CITY OF ALBUQUERQUE

**Re: ANM Jefferson Plaza
4001 Jefferson Plaza NE 87109
30-Day Temporary Certificate of Occupancy
Transportation Development Final Inspection
Engineer's/Architect's Stamp dated 1-8-19 (E17D016E2)
Certification dated 7-8-19**

Ernie Gomez
Plan Checker, Planning Dept.
Development Review Services

A1 SITE PLAN - TRAFFIC CIRCULATION LAYOUT PLAN

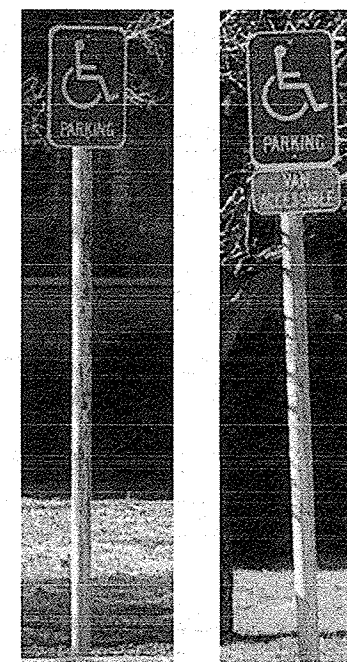
1. Please re-stripe/reconfigure ADA Stalls & Access aisle's for access to ramps. Unusable access aisle's between island. (See Attached Photos)
2. ADA ramps missing detectable surface. (Truncated Domes preferred) See Approved TCL plan.
